WEST SUSSEX COUNTY COUNCIL CONSULTATION

TO:	Arun District Council - FAO: A Gardner
FROM:	WSCC - Highways Authority
DATE:	26 November 2021
LOCATION:	Land rear of Paynters Croft Burndell Road Arundel BN18 0HR
SUBJECT:	F/22/21/PL 23 No dwellings with associated access, infrastructure, landscape and open space (resubmission following F/5/21/PL). This application is a Departure from the Development Plan & is in CIL Zone 3 and is CIL Liable as new dwellings.
RECOMMENDATION:	More Information

Drawing Status	FINAL		
Client	Driftstone Homes		
Project	Burdell Road, Yapton		
Drawing Title	Access Overview and Visibility Splays		
Scale	1:250	Date	July 21
Drawn By	SMO	Checked By	ALB
Drawing No.	2020-6145-001		Rev.
		I

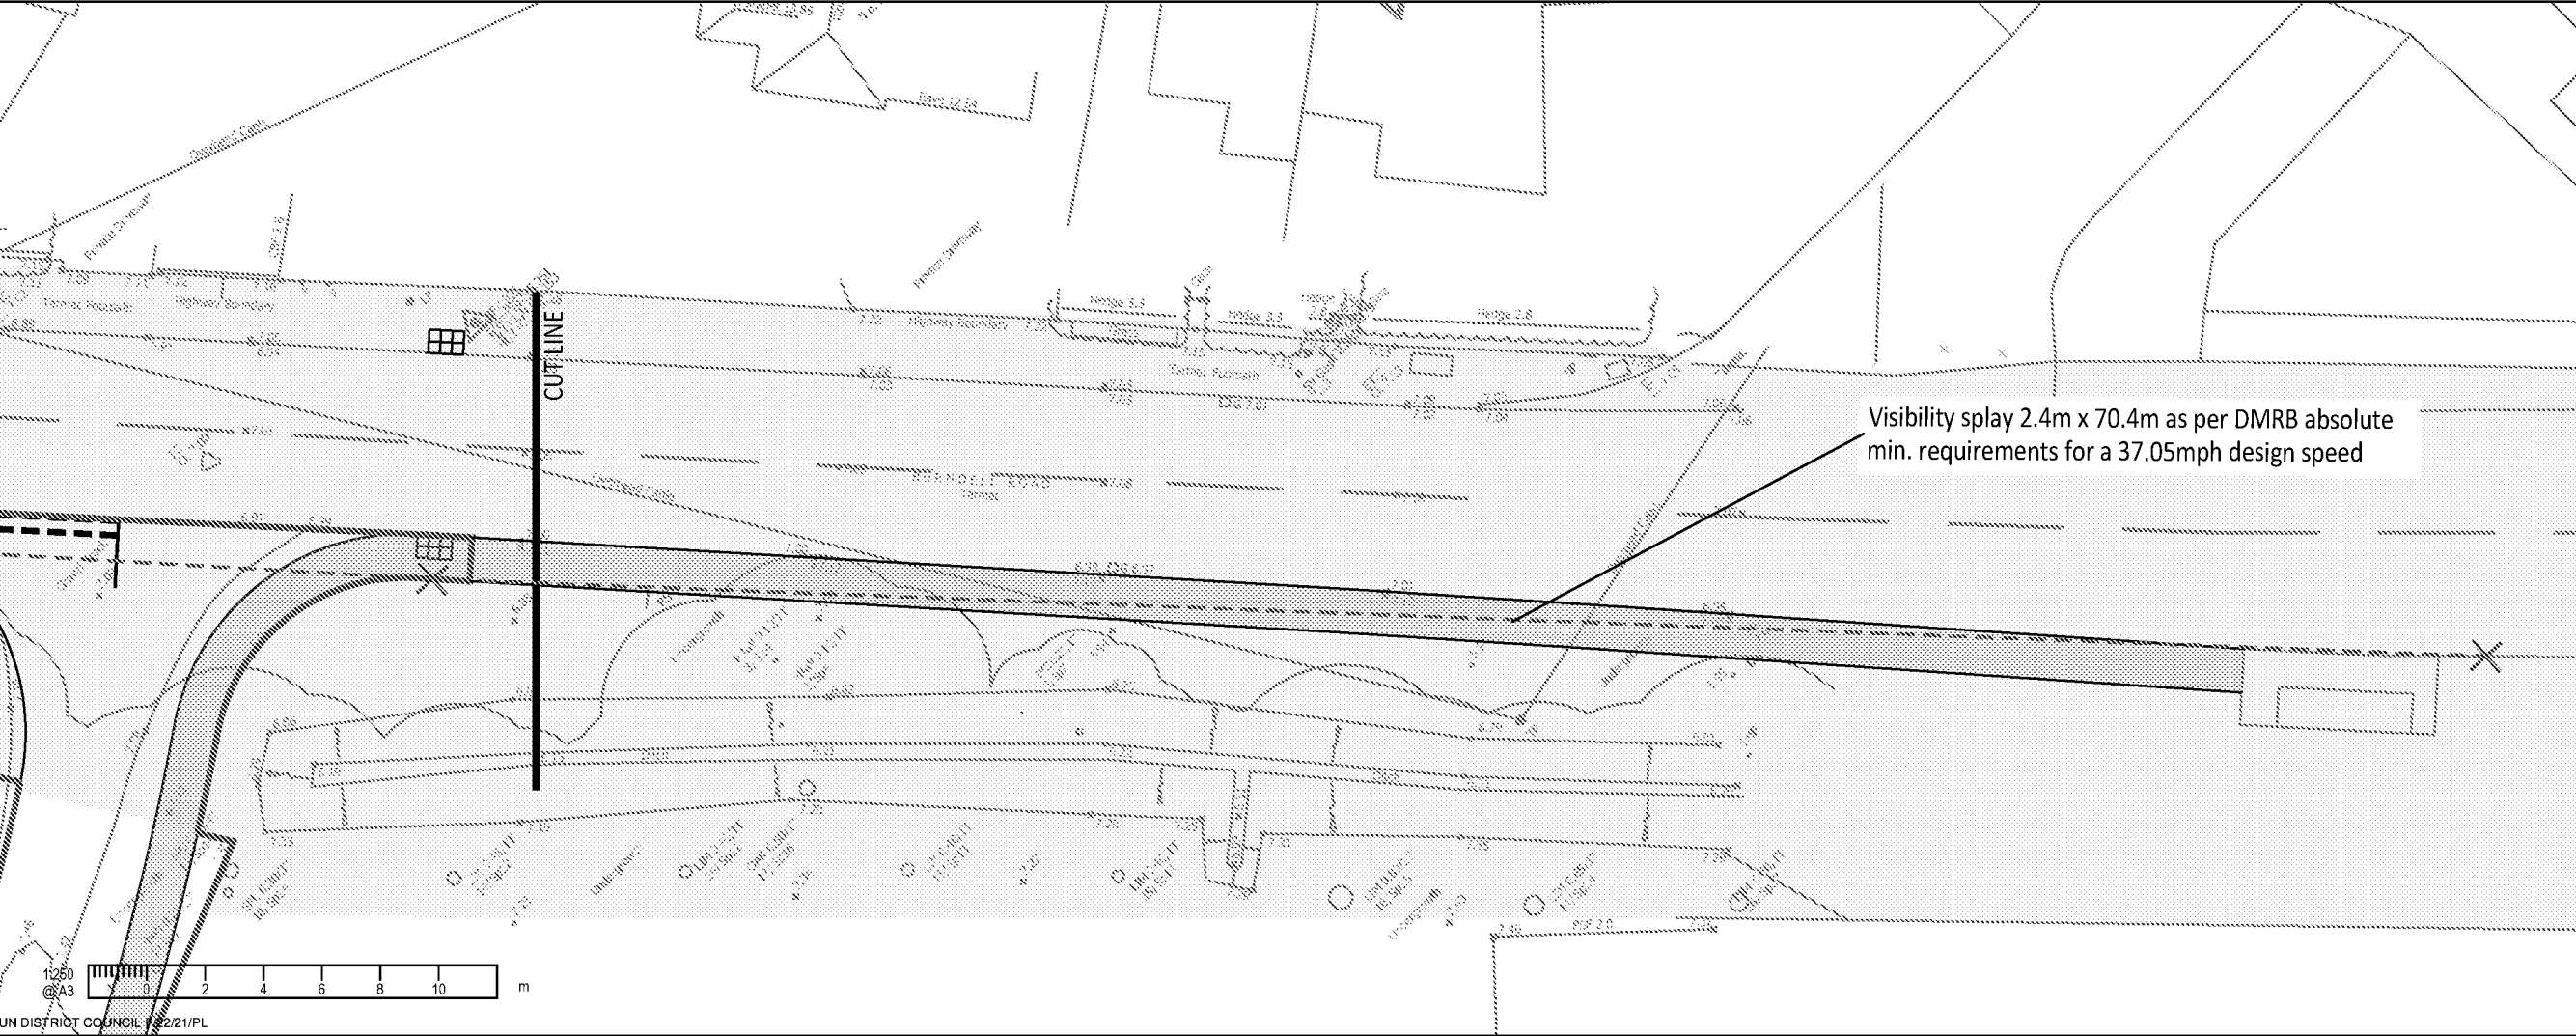
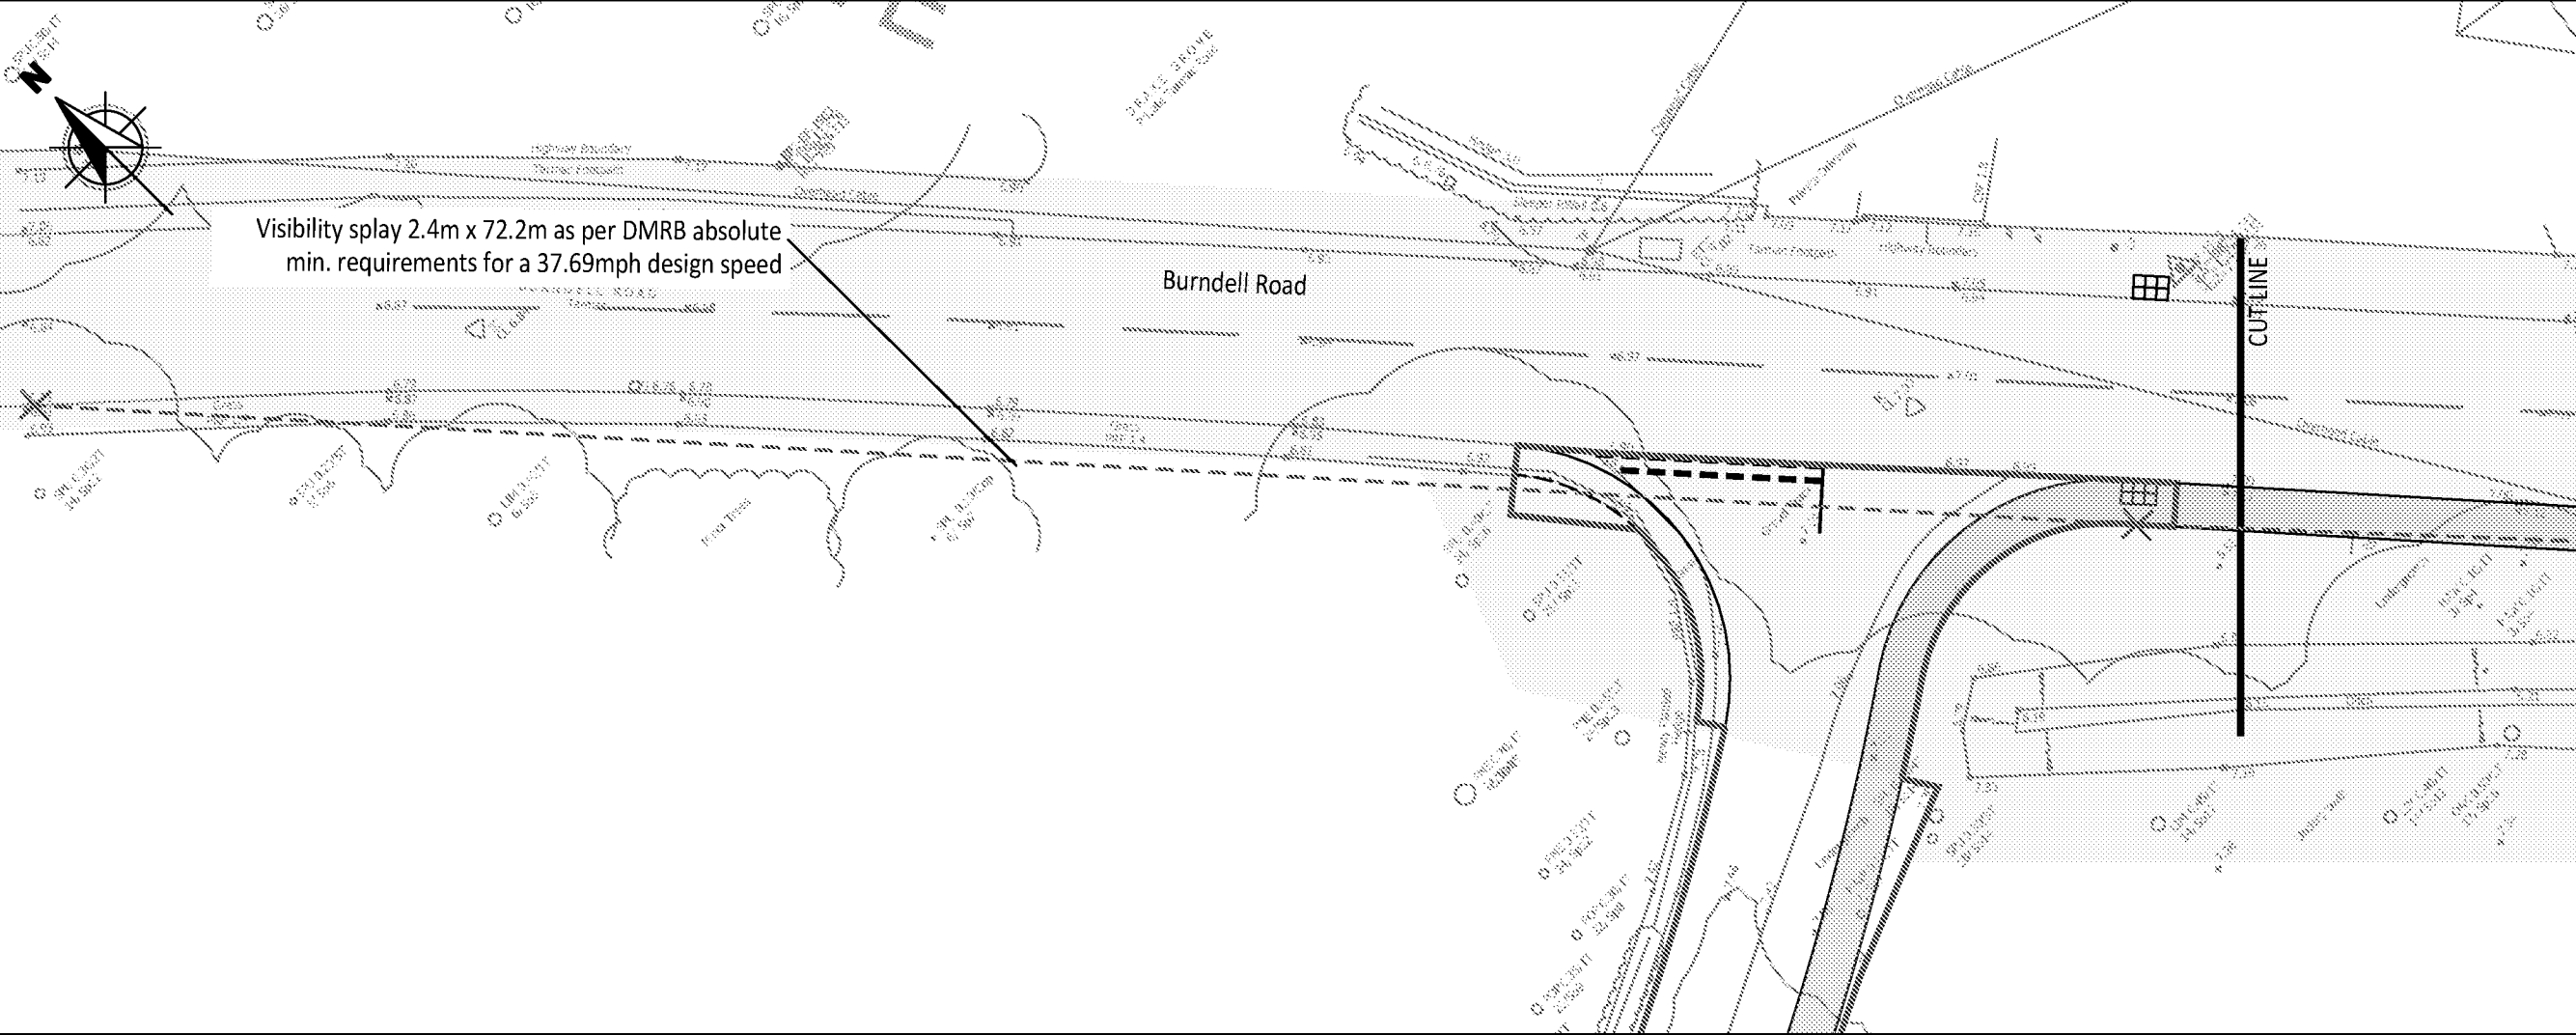
Visibility and tracking plans appear to be provided for the old layout and the extended footway to the bus stop is not shown. However, plans 2020-6145-001 Rev I and 2020-6145-005 Rev C do show these changes and these are the plans that should be referred to in any decision notice.

A seven day ATC Speed Survey has been undertaken to ascertain 85th percentile speeds. The raw speed survey data and location of counter should be provided. Speeds of 37.05mph northbound and 37.69mph southbound were recorded. Taking in to account local road context and that speeds are below 40mph, the LHA would apply Manual for Streets (MfS) to calculate stopping sight distance (MfS2 para. 1.3.6). A requirement of 2.4m by 58m south and 60m north would be needed. The plans show 72m in either direction however it is not clear if the northern splay is achievable entirely within applicant and adopted highway land. Please provide a clearer plan including red edge and ideally extent of publicly maintained highway boundary to ensure splays do not pass through third party land.

- Show splays of 2.4m by 58m south and 60m north can be accommodated without passing through third party land.
- Clearly show extent of footway from access road past plots 1 and 2.
- Ensure single garages of 3m width.
